Kirklees Metropolitan Borough Council
Development Management

Our ref: RA/2025/148811/02-L01
Your ref: 2025/92327

Erection of 4 dwellings (within a conservation area)

Land Adjacent To, 185, Woodhead Road, Holmbridge, HD9 2NW

Proposed River Level Plan - 1:200

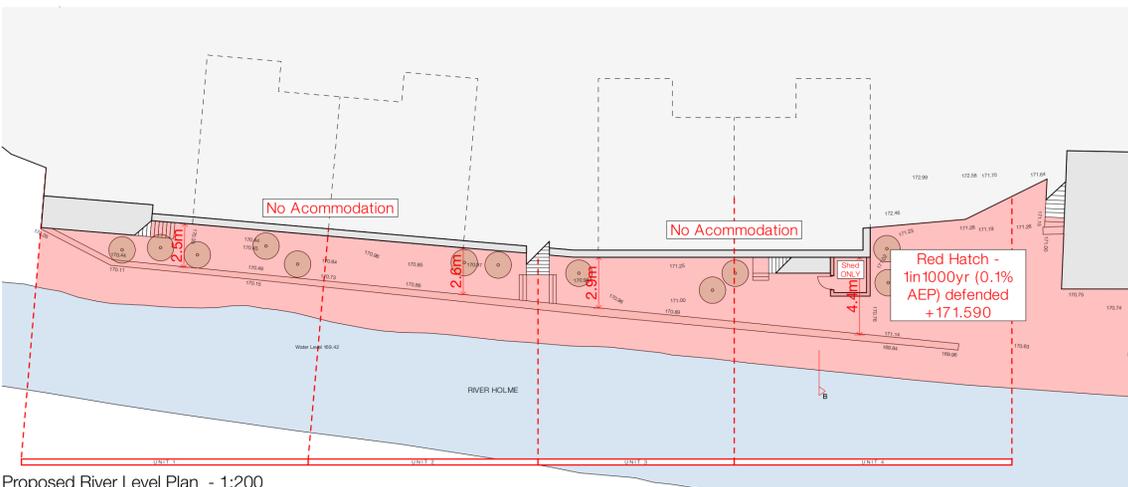
The proposed development would restrict maintenance and emergency access to the watercourse. The permanent retention of a continuous unobstructed area is an essential requirement for future maintenance and/or improvement works.

It is unclear from the information provided whether the proposed development would affect bank stability.

Whilst the FRA has been updated to state "The site will maintain a continuous, unobstructed easement of 6 metres measured from the top of the river bank", the drawings still show that the proposed development will be within this 6m easement.

The applicant should submit a report to demonstrate that the proposed development will not negatively impact bank stability.
